Rezoning Transportation Analysis

Petition Number: 2019-128

Revision Log:

Date	Description
10-21-2019	First Review (EL)
06-26-2020	Second Review (EL)
08-21-2020	Third Review (KP)
09-21-2020	Fourth Review (KP)

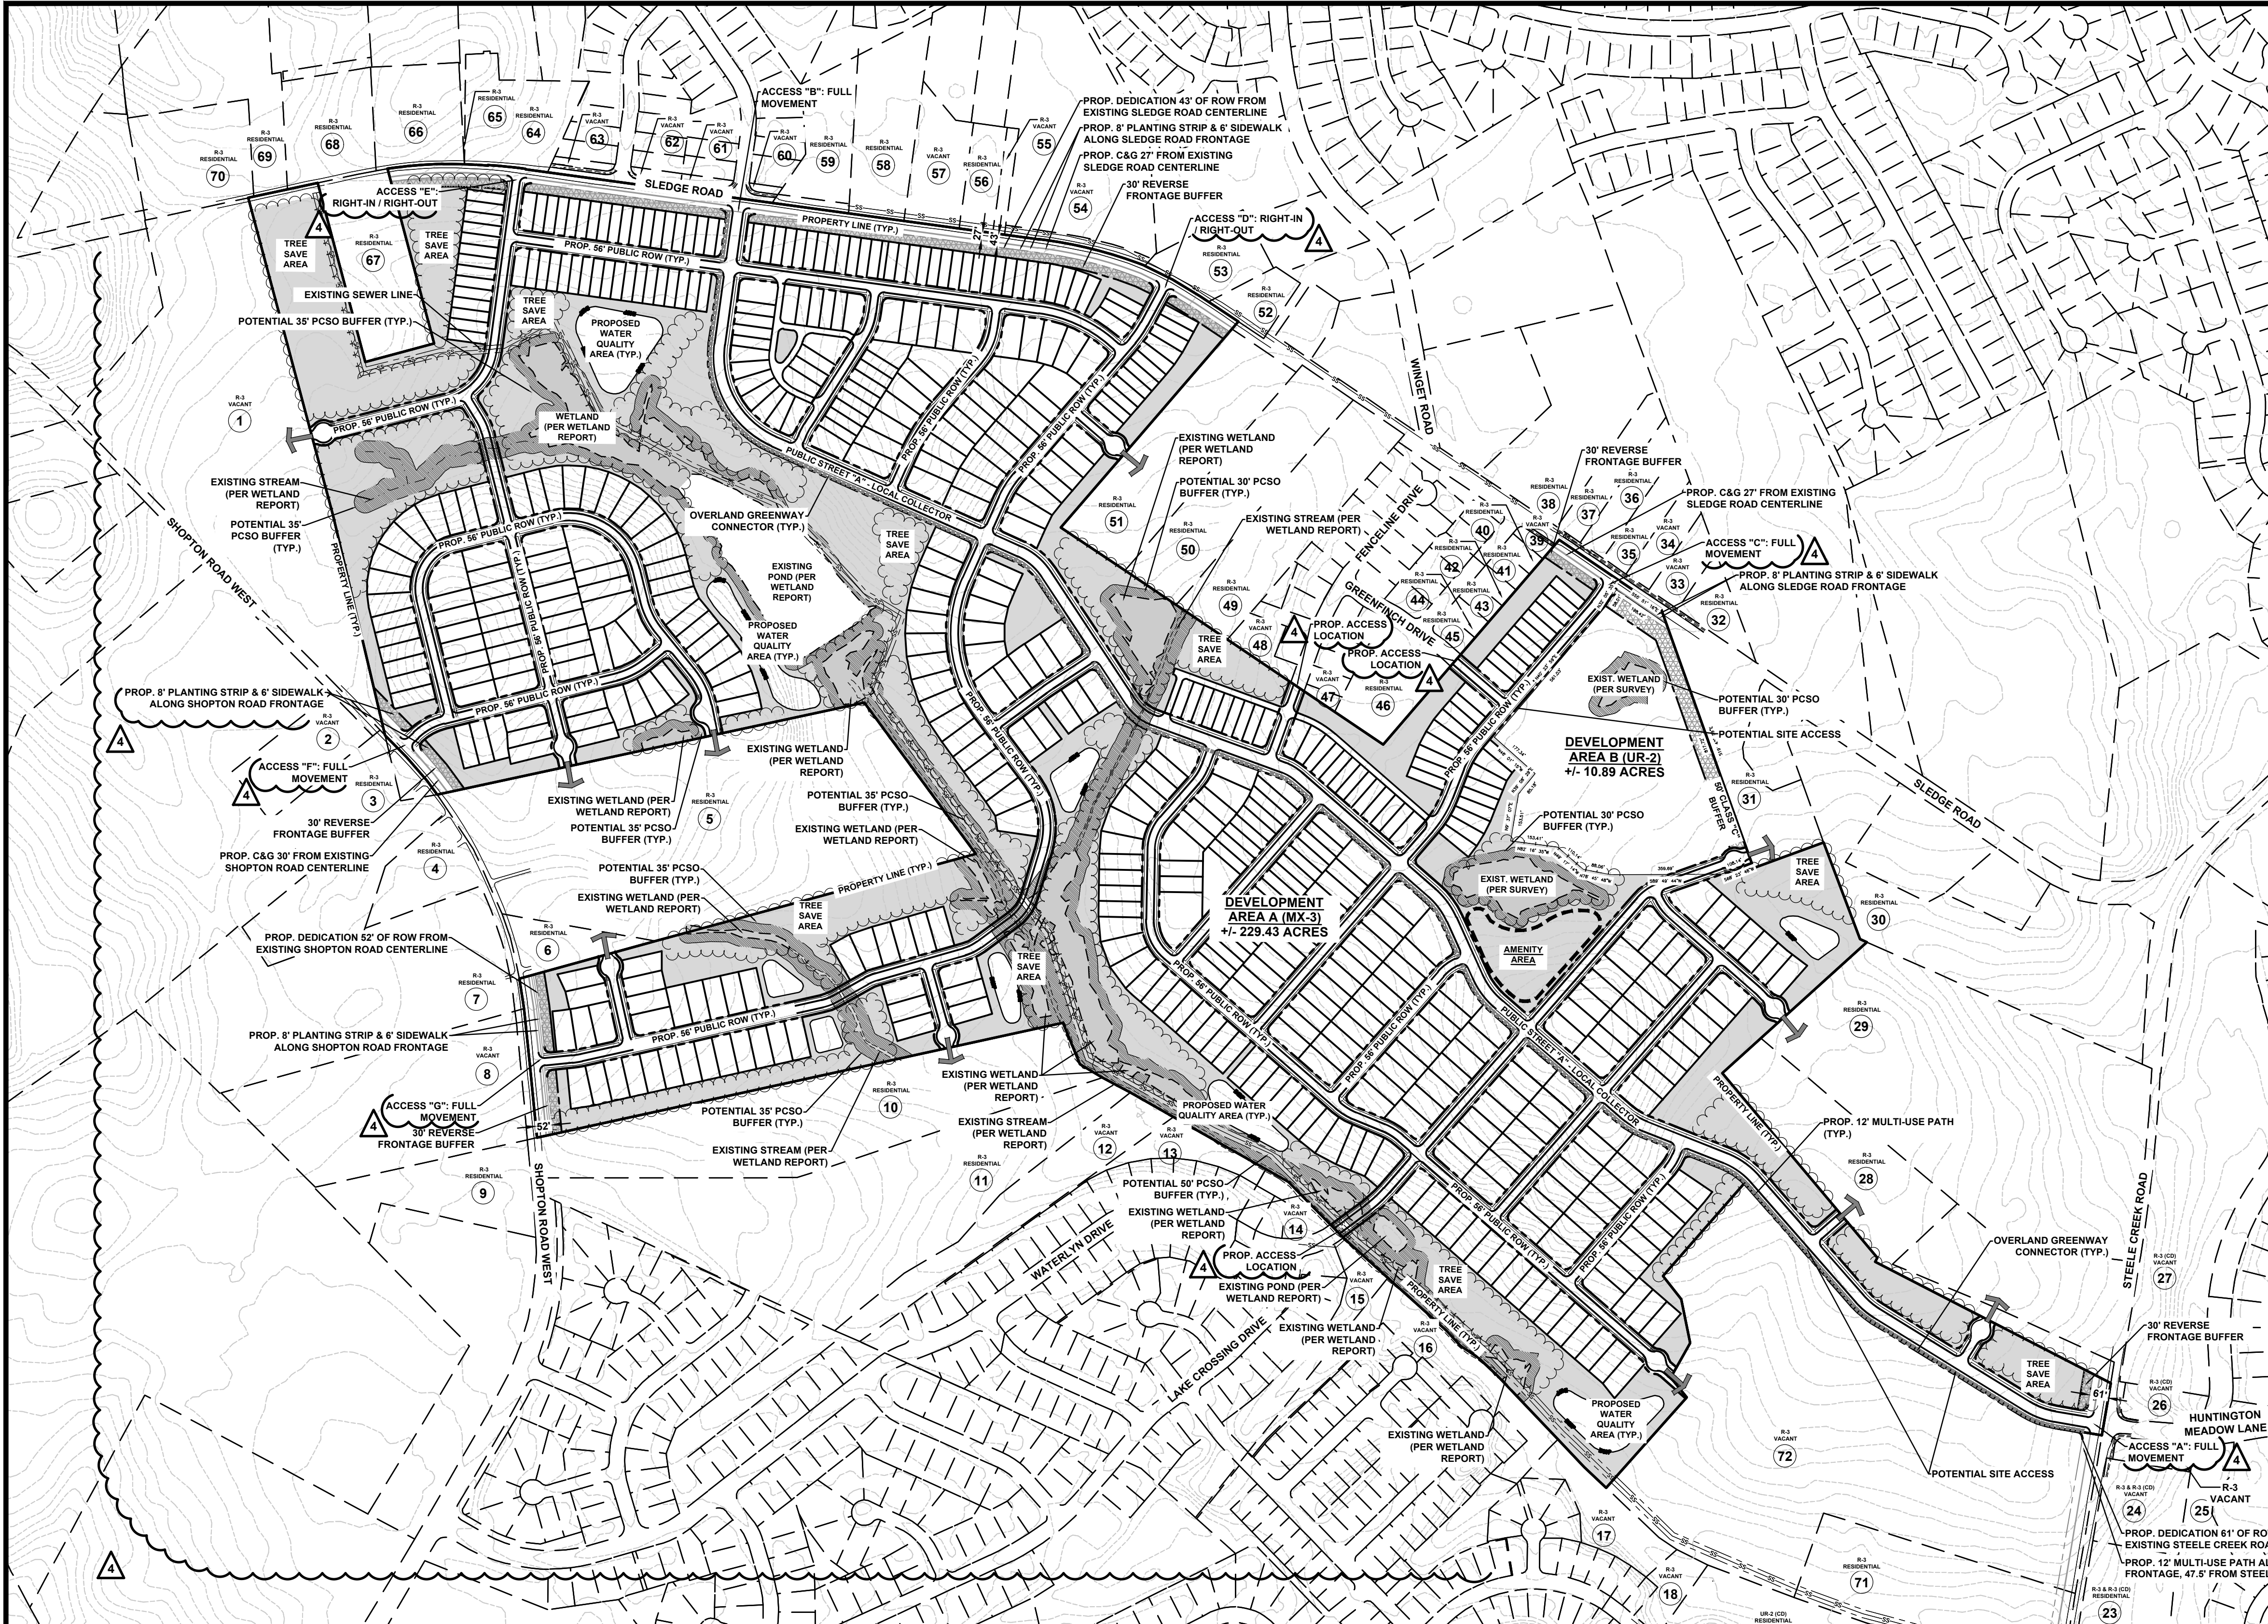
1. **Curbline** The proposed zoning district has a setback measured from back of the existing or proposed future curbline. **Updated Comment from 09-15-2020 Site Plan: Label and dimension the curb lines from the centerline.**
 - a. **Steele Creek Road:** The future location of curb and gutter will be constructed within the Steele Creek Road (NC 160) U-5766 project. The public meeting map and proposed cross section are provided below for reference.

- b. **Sledge Road:** Location of curb and gutter should be moved to 27 feet from existing centerline, to accommodate for the Comprehensive Transportation Plan's recommended thoroughfare improvements for a future 2-way divided buffered bike lane cross section. The site plan should show the curb and gutter labeled and dimensioned from the centerline for each road.

- e. **Shopton Road:** Location of curb and gutter should be moved to 30 feet from existing centerline, to accommodate for the Comprehensive Transportation Plan's recommended thoroughfare improvements for a future 4-way divided (USDG Avenue) roadway section.

Update to Comment from 09-15-2020 Site Plan: Dimension the right-of-way from the centerline. Please show this dedication in front at Access L. All rights-of-way, curb lines, planting strips, and sidewalks/MUPs need to be labeled and dimensioned on **all frontages/access locations**. Typ.
6. The petitioner should revise the site plan and conditional note(s) to commit to construct a 6-foot sidewalk along of the frontage of Shopton Road and to establish a connection to the existing sidewalk stub provided by the existing Waterlyn Subdivision. The site plan should label and dimension both items from the back of curb and gutter and road centerline.

7. The petitioner should revise the site plan and conditional note(s) to commit to dedicate 61 feet of right-of-way from the existing Steele Creek Road centerline, to account for an additional 2 feet from the back of the proposed multi-use path. ~~Update to Comment: This right-of-way should be dimensioned from the centerline.~~

9. The petitioner should revise the site plan and conditional note(s) to commit to construct a 12-foot multi-use path along of the frontage of Steele Creek Road 47.5 feet from existing centerline. The site plan should label and dimension both items from the back of curb and gutter and road centerline.

10. The petitioner should revise the site plan and conditional note(s) to specify each proposed street's USDG cross section.
11. The petitioner should revise the site plan and conditional note(s) to propose the recommended greenway alignment to the McDowell Nature Center and Preserve, per the Council-adopted Steele Creek Area Plan.

12. The petitioner should revise the site plan and conditional note(s) to incorporate a proposed mini-roundabout on proposed Public Street "A."

13. The petitioner should revise the site plan and conditional note(s) to revise Public Street "A" to a Local Collector Street Section, per CLDSM U-07, as required by Sec. 20-23(k) of the Subdivision Ordinance and the City-council adopted Collector Street Map. In lieu of the proposed 10-foot multi-use path, a 12-foot multi-use path should be provided along the western streetscape to provide an overland connector to the recommended greenway alignment to the McDowell Nature Center and Preserve.

14. The petitioner should revise the site plan and conditional note(s) to establish a street connection to "Development Area C."

Updated Comment with 09-15-2020 Site Plan: "Development Area C" was removed and/or not labeled, however, access was provided. Please clarify.
